Your Ref EN020021

Our Ref IPP - 36

Application by SP Manweb for an Order Granting Development Consent for the Reinforcement to the North Shropshire Electricity Distribution Network

Canal & River Trust Response submission for deadline one

Drawing Title:
Viewpoint 8: View from the Montgomery Canal / The Shropshire Way Trail

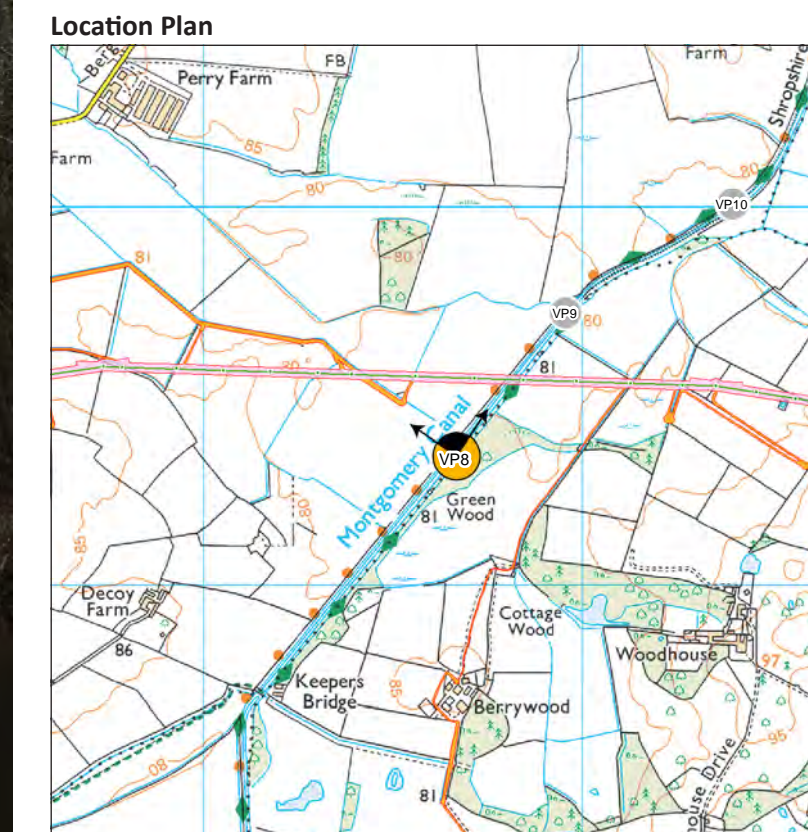
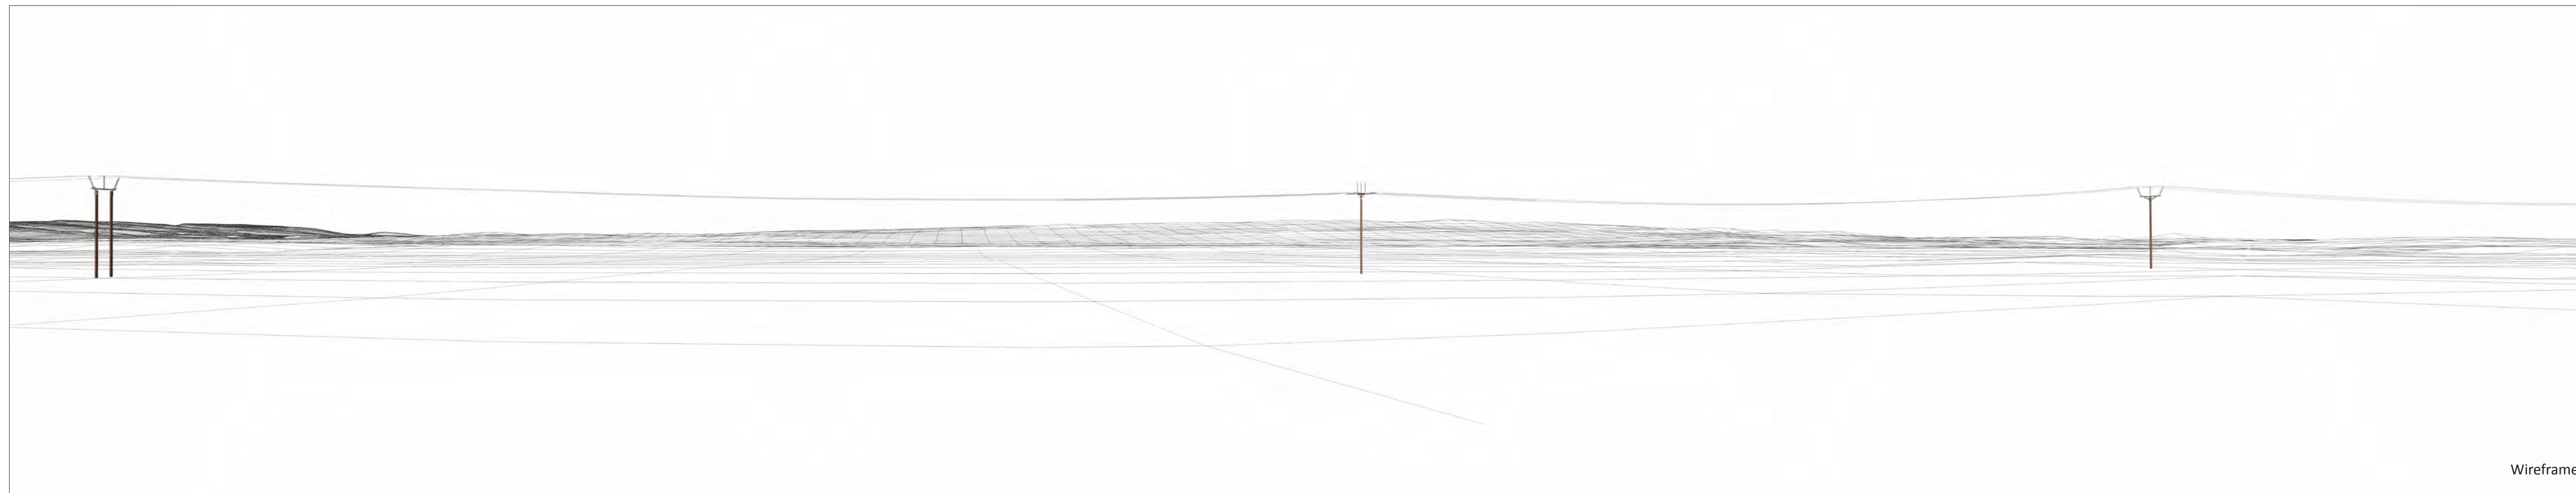
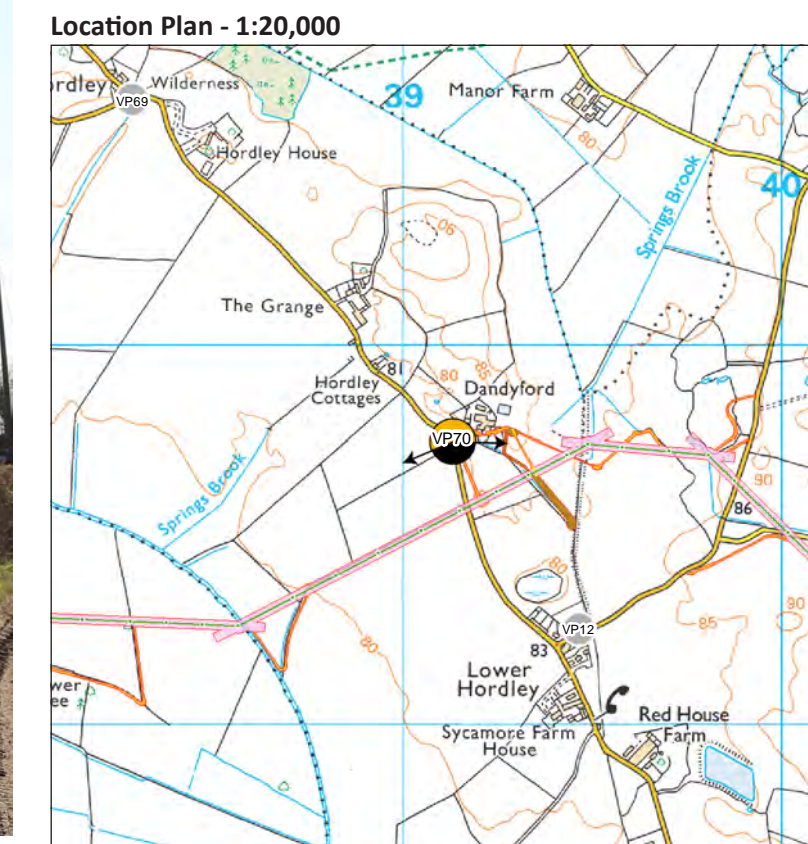
The Trust note the proposal to hold the accompanied site inspection on 11 April 2019 and ask that as part of the visit, the Examining Authority (ExA) walks the towpath of the Montgomery Canal past the site where the overhead line would cross and back again, in order to appreciate the short, medium and long distance views of the line that would occur for boaters and towpath users in this area, and its resultant landscape impact.

The walk along the canal would demonstrate to the ExA the positive benefits of the canal in this area and the likely impact of the installation of the overhead line on the wider landscape when viewed from the canal corridor, as well as specifically the impacts of the line and supports at the crossing point. These are noted in more detail in our main submissions.

Whilst the documentation details what planting/landscaping will be removed in order to facilitate the line there are no details or proposals of what would be planted in order to provide short and long-term screening and mitigation. This should also address any detriment to habitat or biodiversity as well as the necessary reduction of the impacts of the overhead line and poles.

From the information provided, it is difficult to tell what is proposed and whether it would be sufficient to mitigate for all the impacts of the proposed line and support structures for users of the Montgomery Canal. There also appears to be no mechanism requiring its implementation and maintenance, which is a point of concern to the Trust. We therefore request that full information on the detailed proposals be provided, including their delivery mechanism and how this will be ensured with any degree of certainty. It is suggested that these works should be identified in the submission documents, and then included in the requirements section of the DCO so that it is clear what the works entail and that they are required to be implemented. This would also comply with the requirement in the NPPF for the provision of biodiversity net gains.

### **Montgomery Canal Crossing**

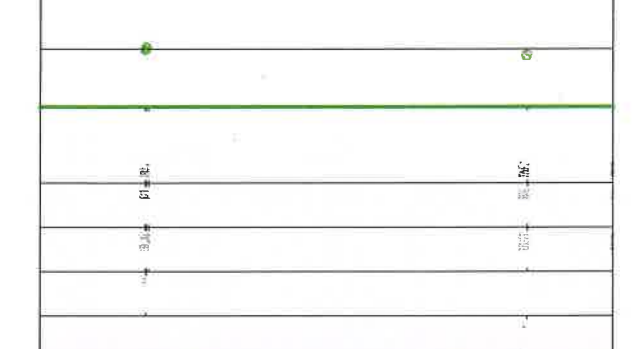
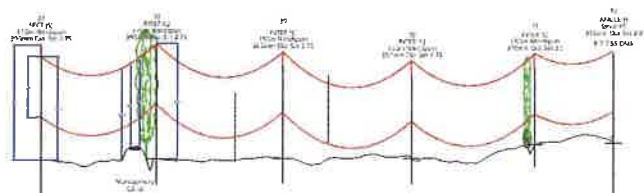
The Trust raised concerns in its relevant representation in relation to the height of poles 37 and 38 and the resultant clearance over the canal. The Trust received information from the applicant in respect of this on 27 March. Given that this information has been provided very close to the deadline for submission of this representation, we have not had the opportunity to review this information. We therefore reserve our position in respect of this until we have reviewed this information.
